# **East Anglia ONE North and East Anglia TWO Offshore Windfarms**

## **Applicants' Comments on Natural England's Deadline 6 Submissions: Responses to RTD statistical analysis**

Applicant: East Anglia TWO and East Anglia ONE North Limited  
Document Reference: ExA.AS-23.D8.V1  
SPR Reference: EA1N\_EA2-DWF-ENV-REP-IBR-001007

Date: 25<sup>th</sup> March 2021  
Revision: Version 1  
Author: Royal HaskoningDHV

Figure 4 Partial plots of smooth covariates

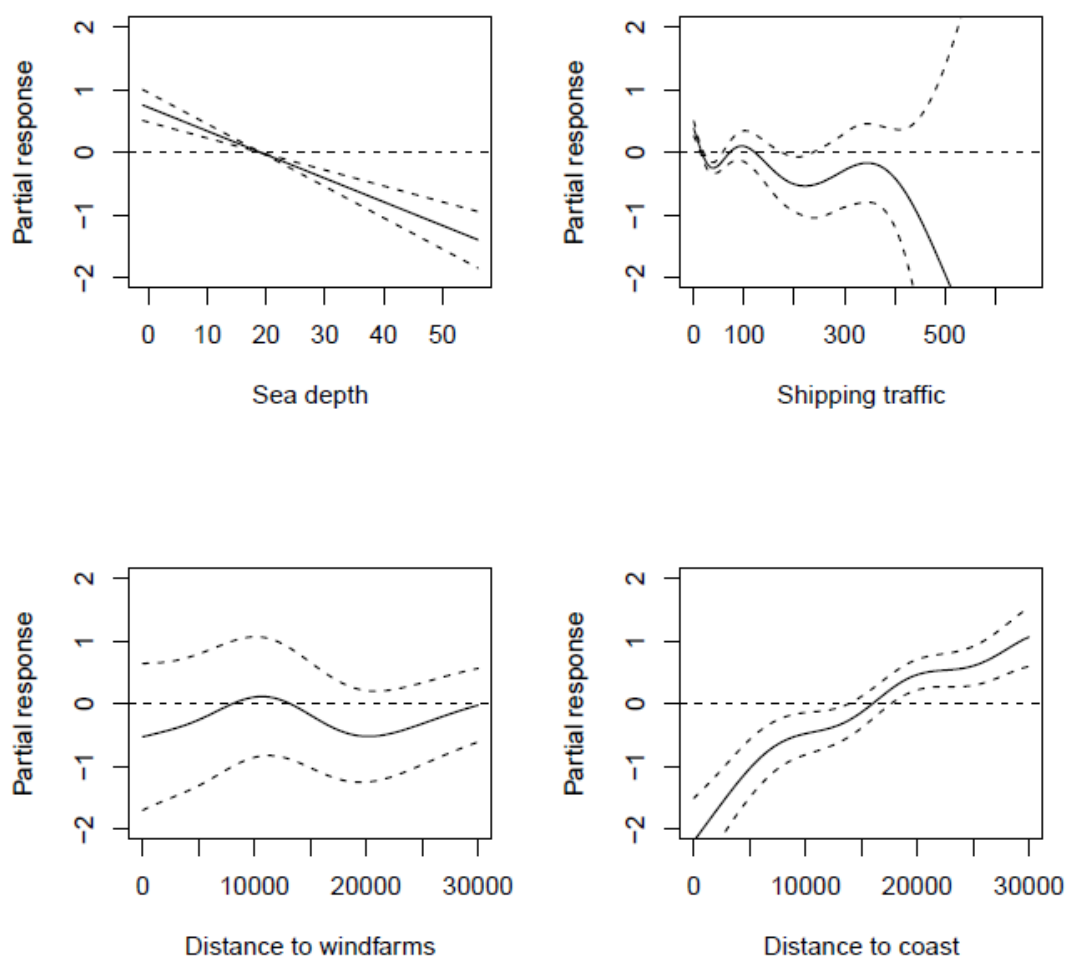
Reference	NE Comment	Applicants' Comments
	<p>expected that by removing the weak relationship, only a weak relative change in abundance would be detected.</p> <p>The Applicant states that they have considered this matter further by reviewing the partial plots of the time specific spatial layers (Figure 4 in Appendix 1) and found no similarity between the fitted spatial effects and the location of windfarms, and therefore assert that pseudo-replication is not an issue. However, the results of this review have not been shown in the report and therefore we are unable to agree with the Applicant's position. Furthermore, we would have expected to see a check of collinearity of the covariates, and reporting of that process, in order to get a better understanding of the appropriateness of the variables. <u>Provision of this information would allow the robustness of the Applicant's modelling to be better assessed, and should be submitted into the Examination.</u></p>	<p>there could be issues of concurvity, however these are often betrayed by volatile behaviour in the predictions of the model, which have not been observed here.</p>
